Subject: AU-25-00010 Thompson - Notice of Application

CDS is requesting comments on the following Accessory Dwelling Unit application: **AU-25-00010 Thompson**.

TO: All Staff
FROM: Public Works Plan Review Team
DATE: December 23, 2026
SUBJECT: AU-25-00010 Thompson

for adding a ADU
15x56 - 2 BR.
MANUFACTURED HOME

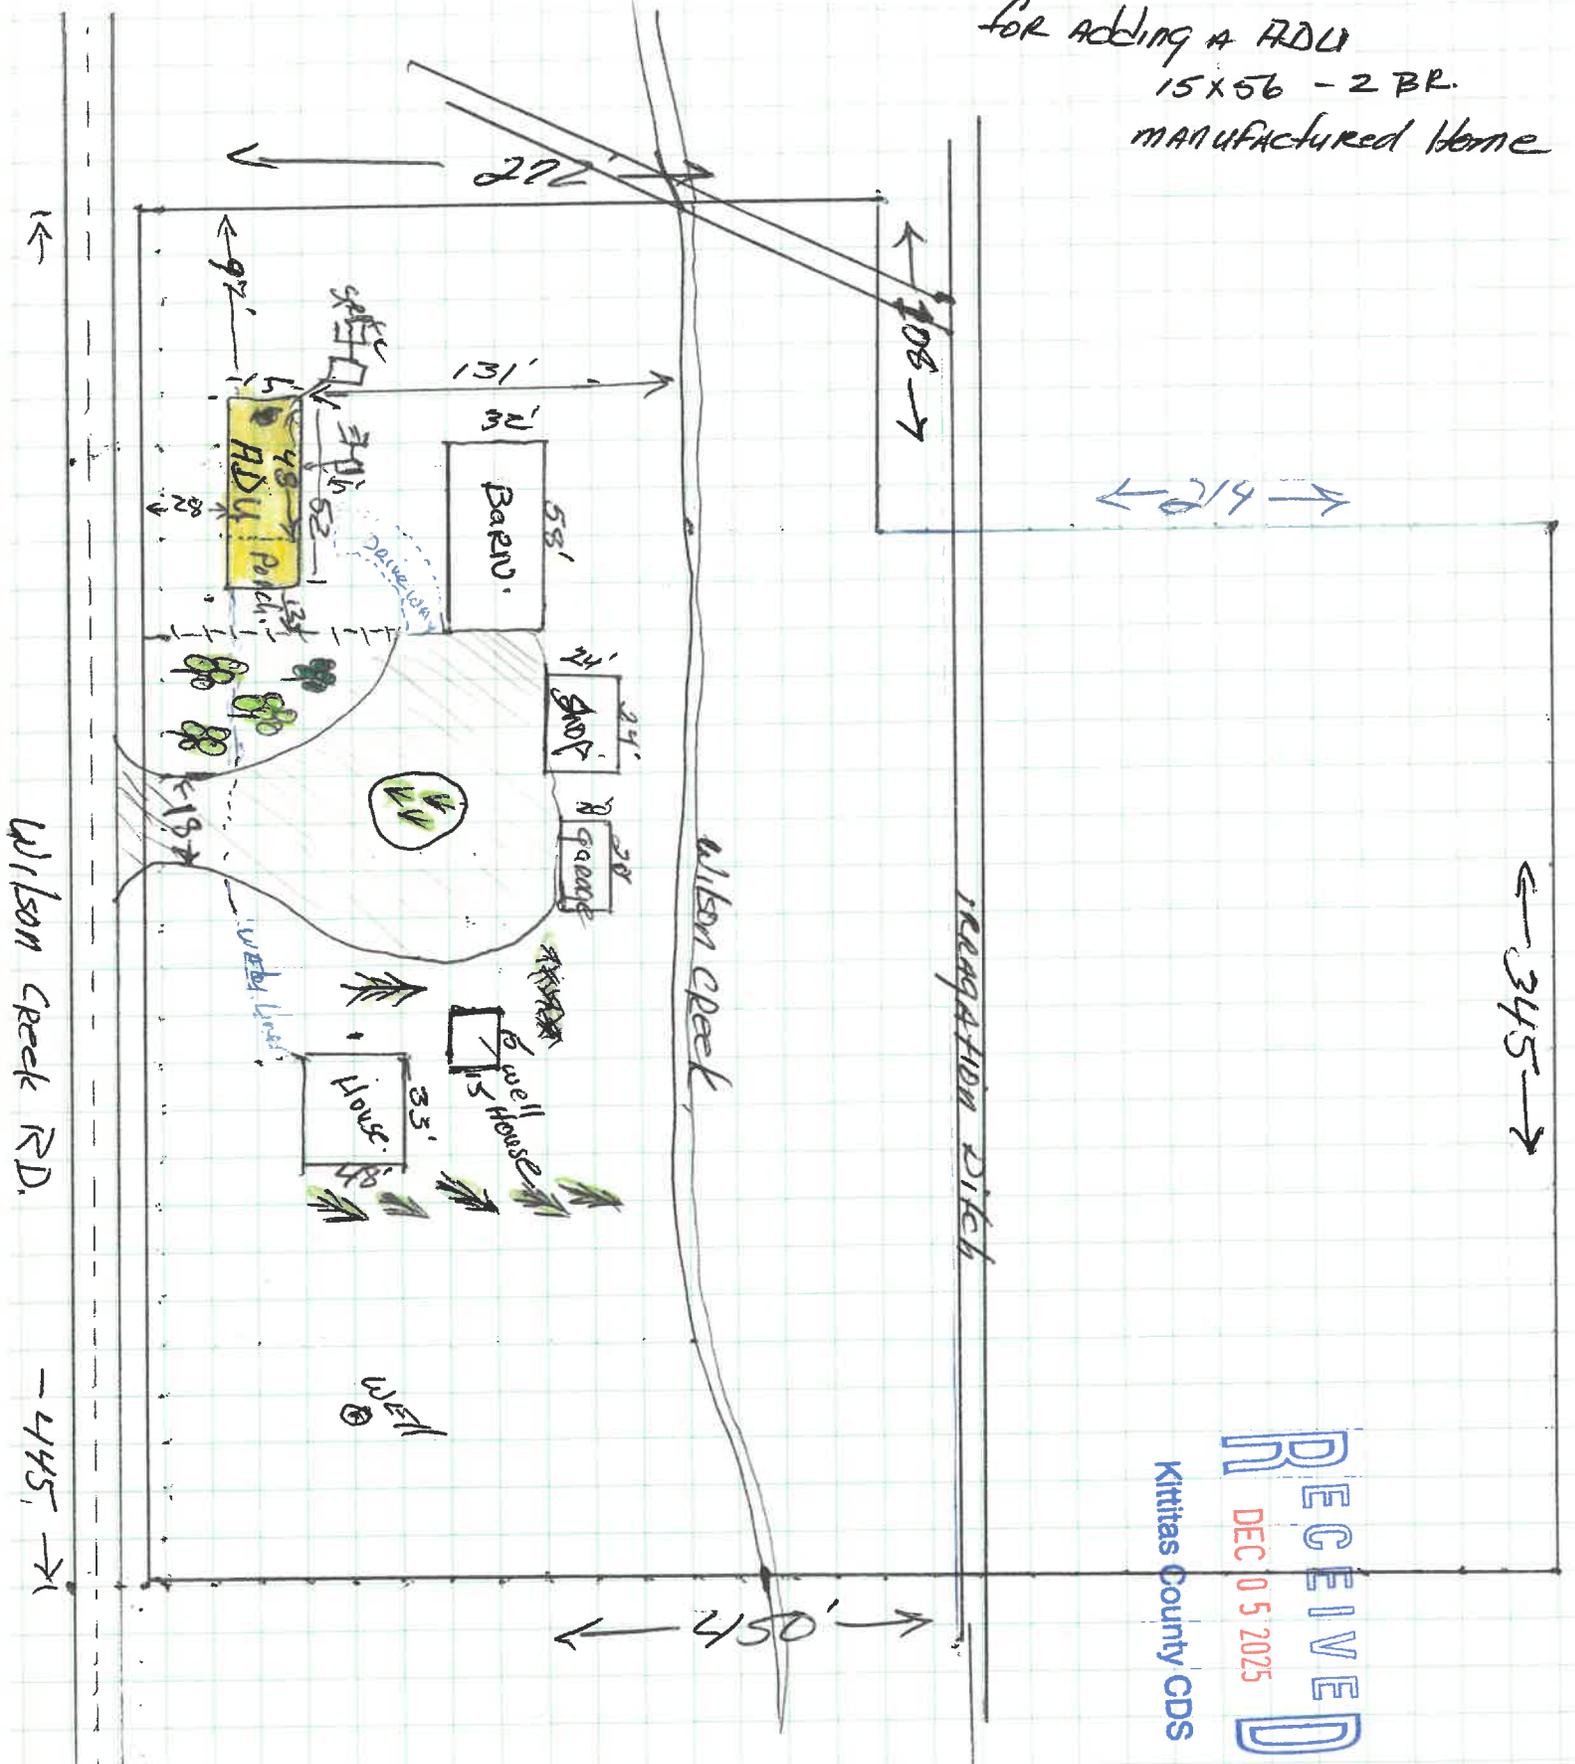
Drinking Water	<ul style="list-style-type: none">• No comment.
Wastewater	<ul style="list-style-type: none">• Site evaluation and septic installation permit approval will be required for ADU connection to current septic system or installation of separate individual septic system.

ACCESS	<ol style="list-style-type: none"> 1. An approved access permit shall be required from the Kittitas County Department of Public Works prior to creating any new driveway access or altering an existing access. 2. Maintenance of driveway approaches shall be the responsibility of the owner whose property they serve. The County will not maintain accesses. 3. Any subdivision or lots to be served by access may result in further access requirements. See Kittitas County Road Standards. <p>In addition to the above-mentioned conditions, all applicable Kittitas County Road Standards apply to this proposal. Access is not guaranteed to any existing or created parcel on this application. (RC)</p>
ENGINEERING	<p>Except as exempted in KCC 14.05.060, no grading or filling upon a site involving more than one hundred (100) cubic yards shall be performed without a grading permit from the County Engineer or Public Works designee (KCC 14.05.050). An application for grading in excess of five hundred (500) cubic yards shall be accompanied by an engineered grading plan (KCC 14.05.080). (CP)</p>

SURVEY	<p>There are no survey comments regarding this application. (JT)</p>
TRANSPORTATION CONCURRENCY	<p>No Comments.</p>
FLOOD	<p>A portion of this property is within the 100-year floodplain. Since the proposed activity is outside the 100-year floodplain a floodplain development permit will not be required.</p> <p>If possible, any future development should also remain outside of the floodplain in order to reduce risk and avoid mandatory flood insurance purchase requirements. All activities within the floodplain must be permitted through the floodplain development permit process and follow the regulations within KCC 14.08. (SC)</p>
WATER MITIGATION/ METERING	<p>Per KCC 13.35.027 water mitigation and metering is required for the ADU since it is a new use of ground water. Water mitigation certificate WM-25-00070 has been issued for this project. (SC)</p>
